Engineers Comments Regarding Surface Water Drainage

Application Reference:	R/93/25/DOC	Reviewer Reference:	ADC/EXT2/D2134/78
Planning Officer:	Simon Davis	Date of Review:	03.09.2025
Site Name:	Rustington Convalescent Home Sea Road Rustington BN16 2LZ		
Application Description:	Approval of details reserved by condition imposed under reference R/258/18/PL relating to condition number 19 - foul and surface water sewerage disposal.		
Assessment Number:	1 of 2

Condition 19: **Further information required**

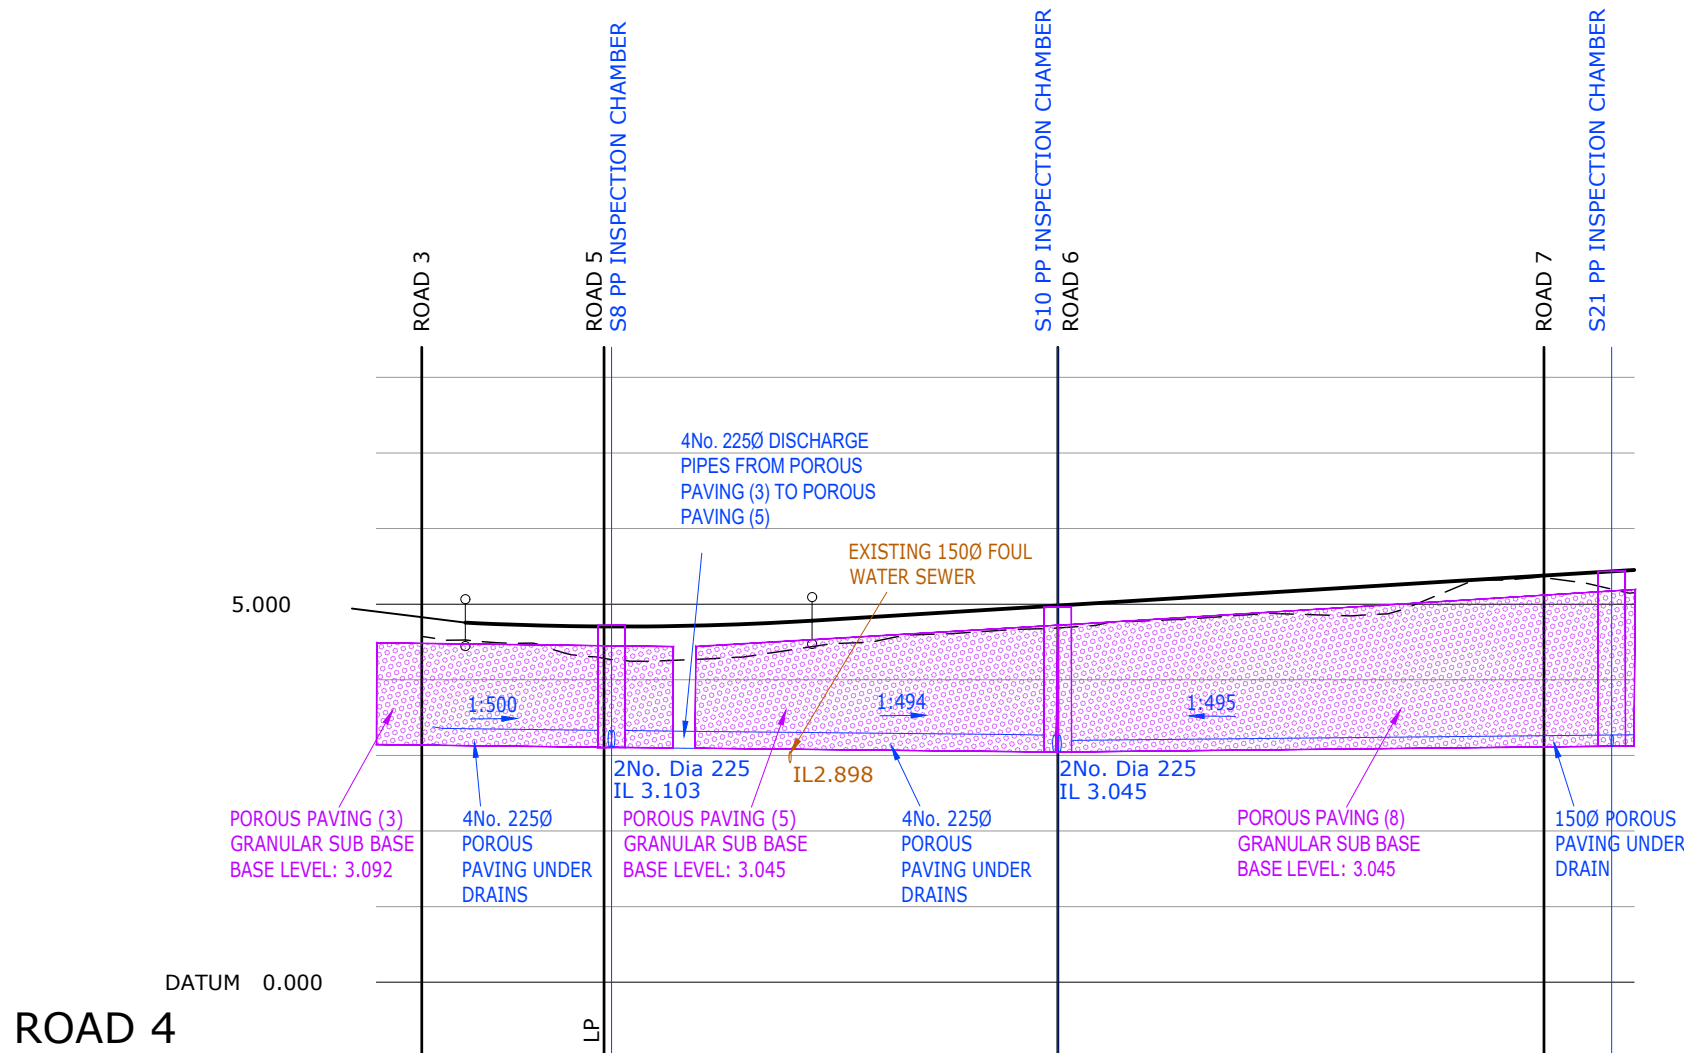
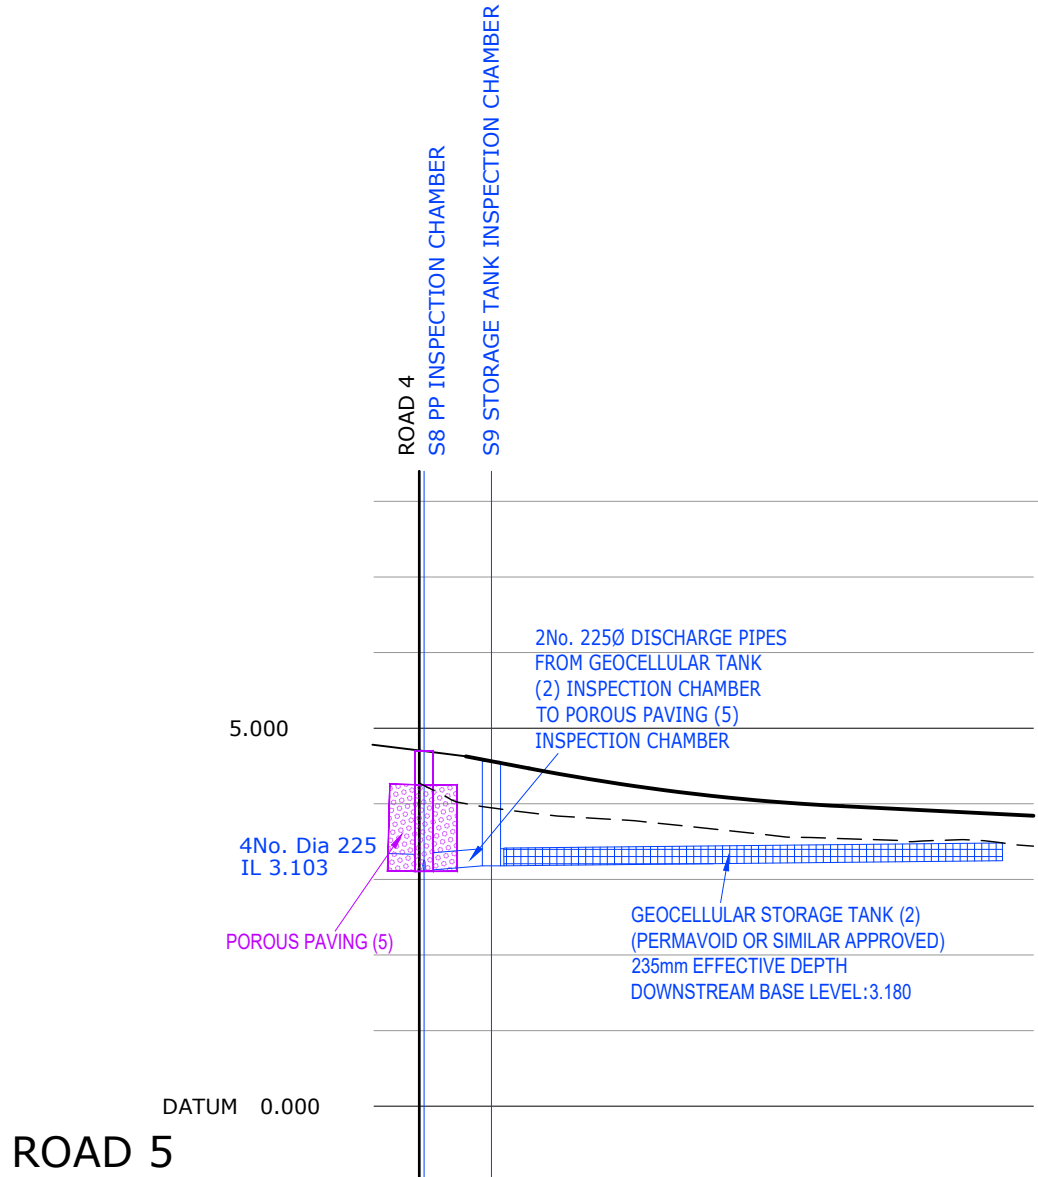
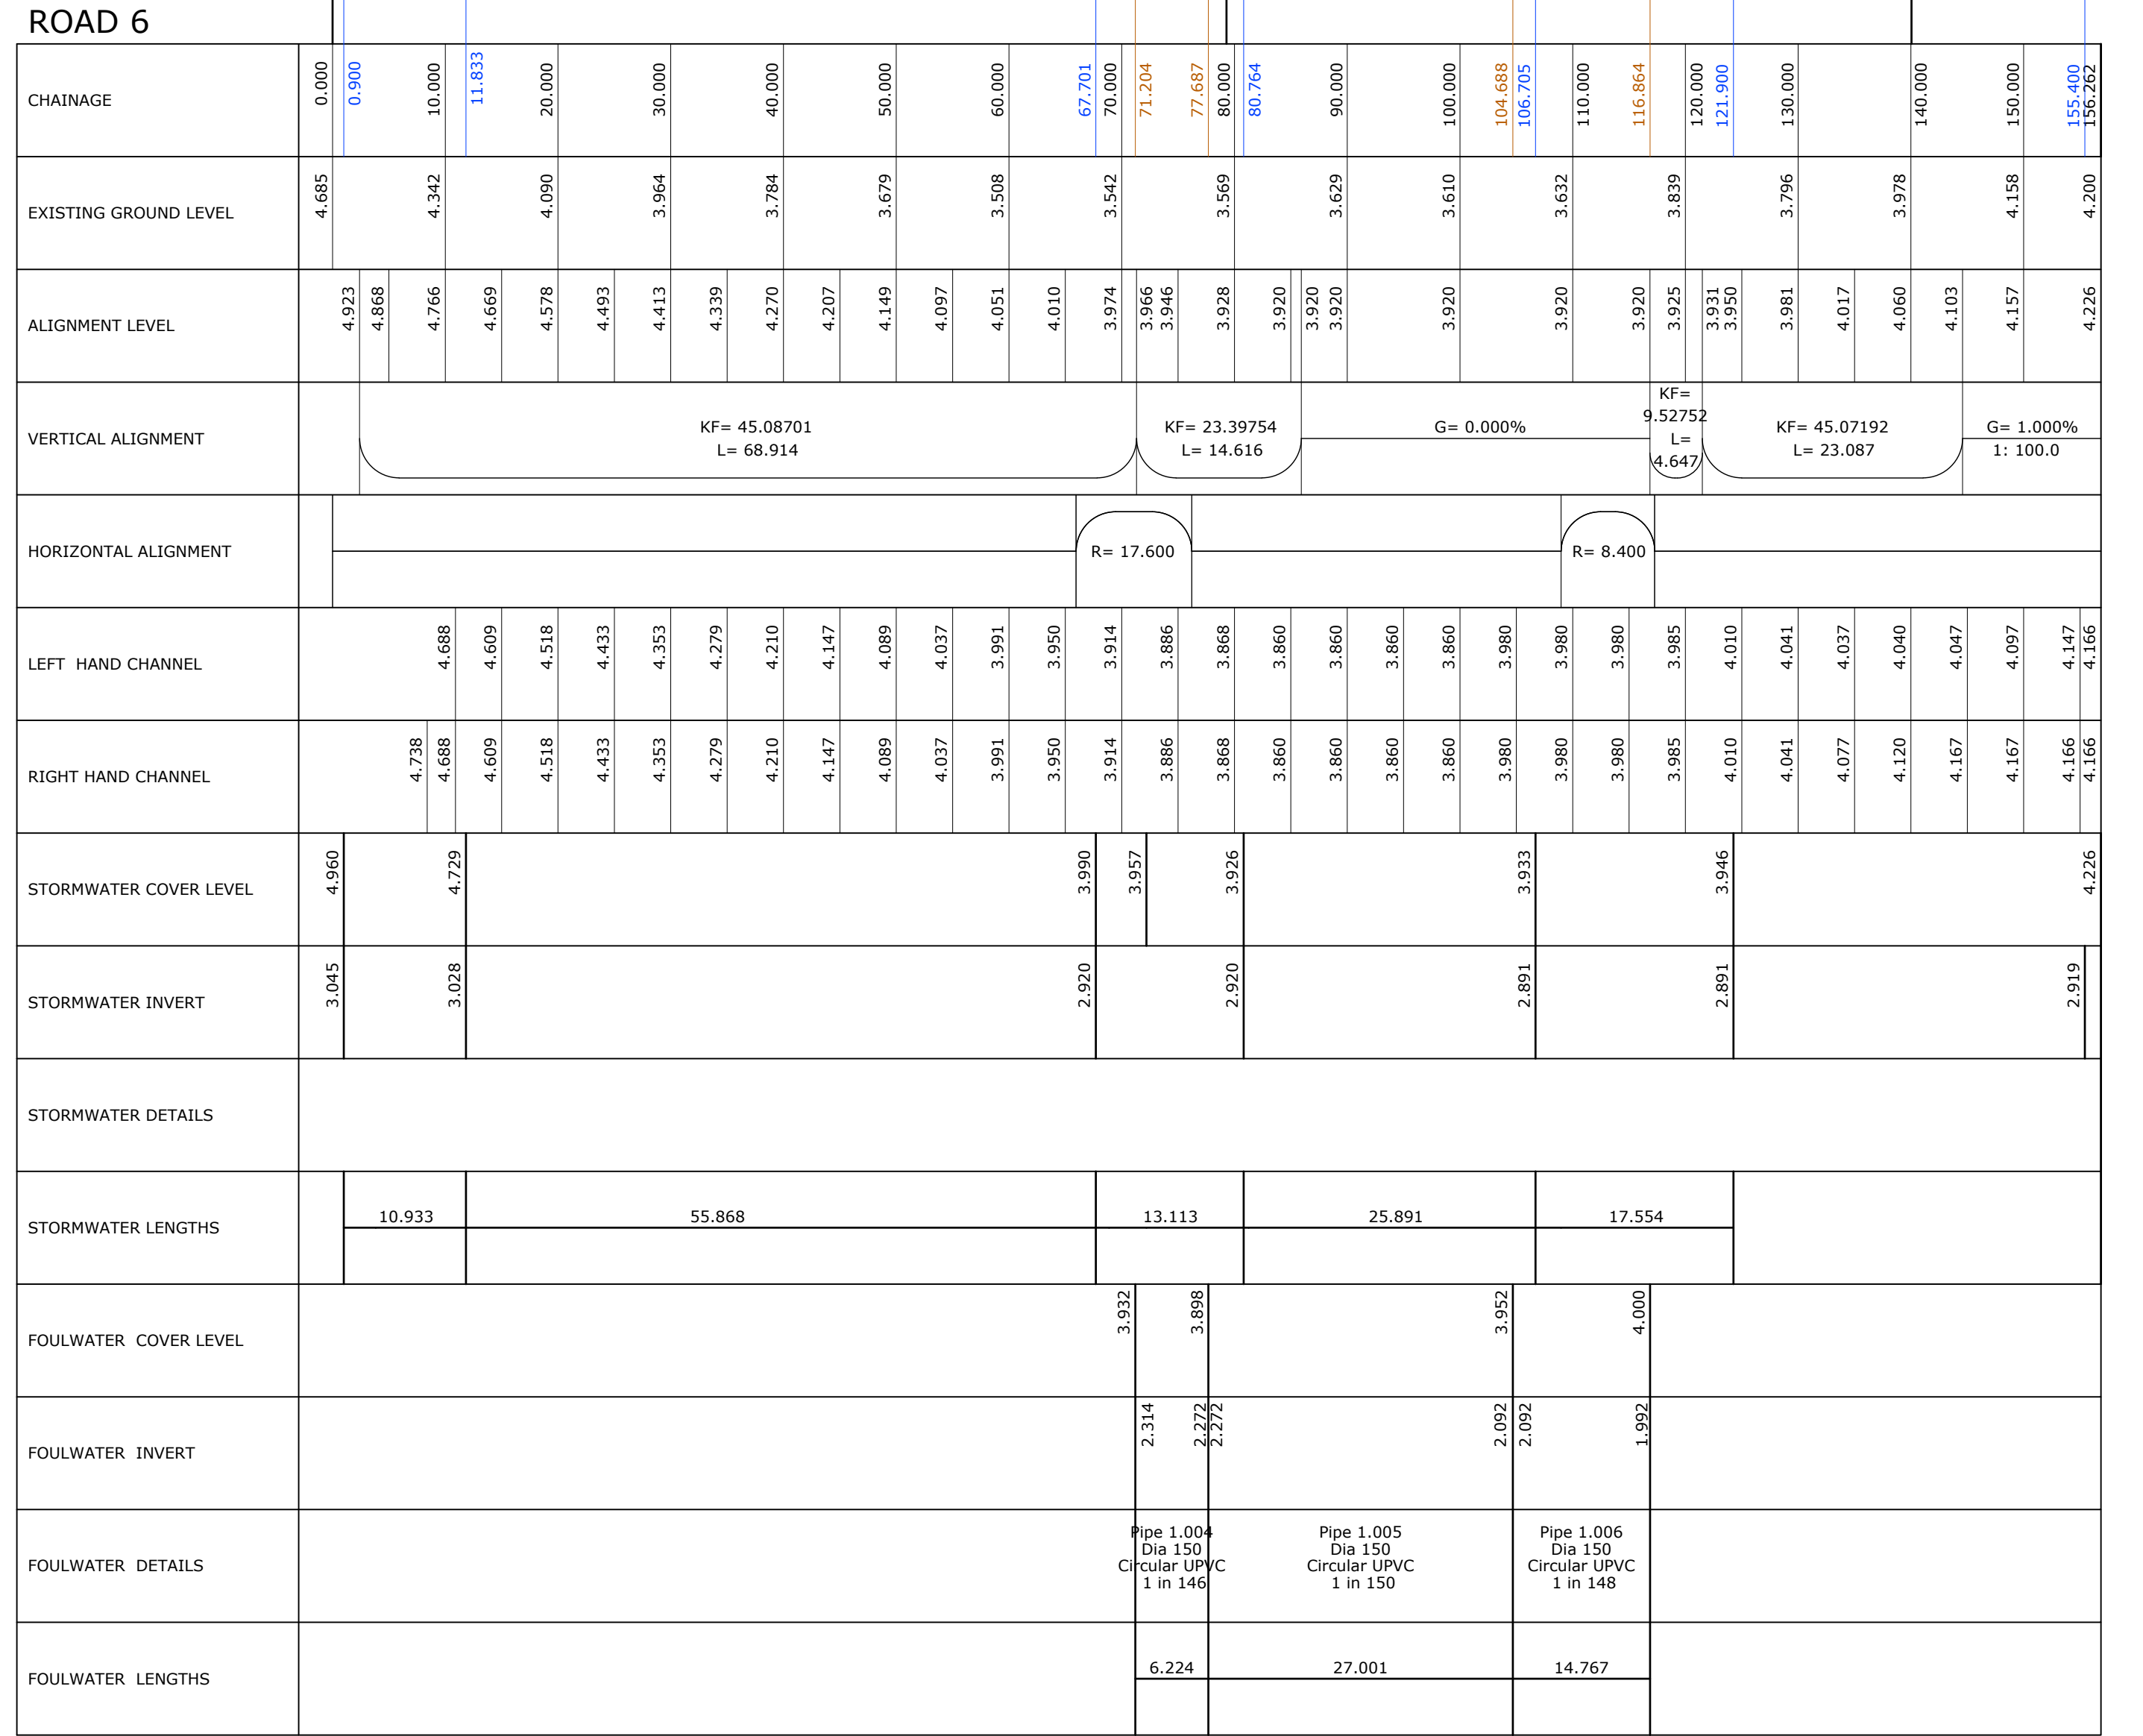
10.	ADC Drainage Comments 28/10/2025: Cross sections are require where there are split permeable paving types and underdrains.	The interconnected sections of PP are provided on drawings 25-043-135 to 138.	As per point '8' response.

Scale 1:250 @A0	Date MAY 25	Designed AK	
Drawn AK	Checked BAC	Approved BAC	
Job No 25-043	Drawing No 25-043-150		Rev -

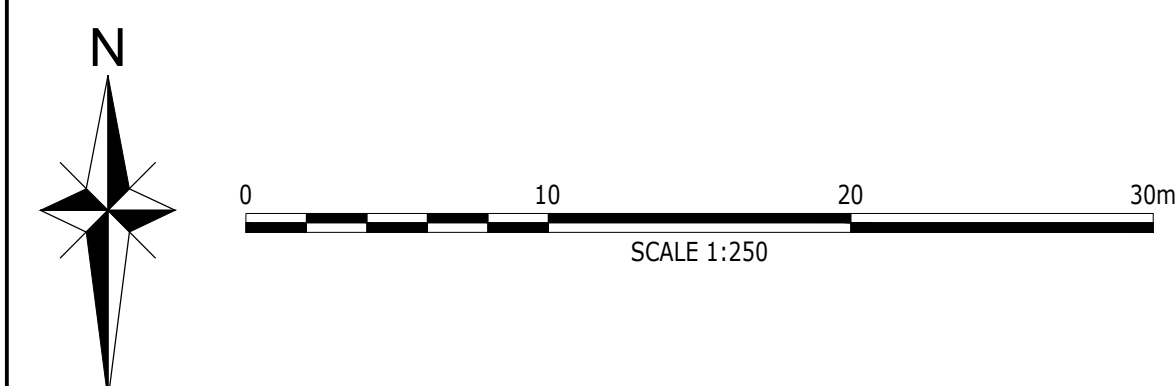
7.	ADC Drainage Comments 28/02/2024: Permeable pavement formation levels must be annotated. Designer Response 25/06/2024: Base levels are shown on the Drainage strategy. ADC Drainage Comments 31/07/2024: Base level appears to be either 2.88 or 2.87; which is correct? It is noted that the permeable sub-base formation is intended to be flat, therefore depths are varied to form the final profile. In some areas depths are noted in excess of 1.44m however Sketch drawing 008 illustrating the stand detail does not qualify the greater depths and if geogrid will be required. Bespoke construction details must be provided for all SUDS features; for permeable pavements any check dams, breaks, pipe links needs to be detailed. The drainage strategy plans illustrative numerous diffusers units with linking under drains, however there is insufficient information on both the plans and detailing to understand so how will the contractor build it.	Although the permeable paving (PP) system is complex the construction detail of permeable paving provided on drawing 123 is universal with only the thickness of sub base being varied – and this would depend on the final surface finish level. The PP sub base level is noted on a dedicated sub-base level drawing 25-043-150. There is no proposal to use geogrid at the moment and any low CBR case would be addressed by adding appropriate capping below PP sub-base. Please refer to drawing 112 where underdrains arrangement is detailed.	Drawing 123 is accepted. The PP sub base formation levels illustrated on drawing 150 is accepted, however the extents of the impermeable liner are impractical for a contractor to install; this needs further consideration to ensure the desired strategy is compliant. Please review in logical blocks and a contractors method statement is provided. Please note underdrain comments below. Why are these needed? How can these be maintained where there are significant bends?

Comment outstanding. Designer Response 18/08/2024: Please see Odyssey drawings 24-059-105, 106 and 107 which indicate sub-base levels for permeable paving at the start and end of respective sections. Please note that for permeable paving where infiltration is used the base is assumed as flat. For permeable paving sections where their main purpose is to convey water (to sections that infiltrate) the levels are provided for the sub-base at its upstream and downstream extent with the constant gradient in between. The thickness of sub-base is not constant and on standard detail drawing 24-059-123 it is noted that "sub-base thickness to be calculated based on the sub-base formation level and surface finished levels". Drawing 24-059-123 together with drawings 24-059-110 and 24-059-111 details appropriate construction for drainage and road make-ups. ADC Drainage Comments 28/10/2025: Base level appear to vary across the site hence this is a complex solution. It is noted that the permeable sub-base formations are mixed being flat and sloped and the depths are variable The permeable details on drawing 123 are too generic and do not reflect the greater depths and if geogrid/structural support will be required. Bespoke construction details (& site cross sections) must be provided for all SUDS features; for permeable pavements any check dams, breaks, pipe links needs to be detailed. The drainage strategy plans illustrative numerous diffusers units with linking under drains, however there is insufficient information on both the plans and detailing to understand so how will the contractor build it.
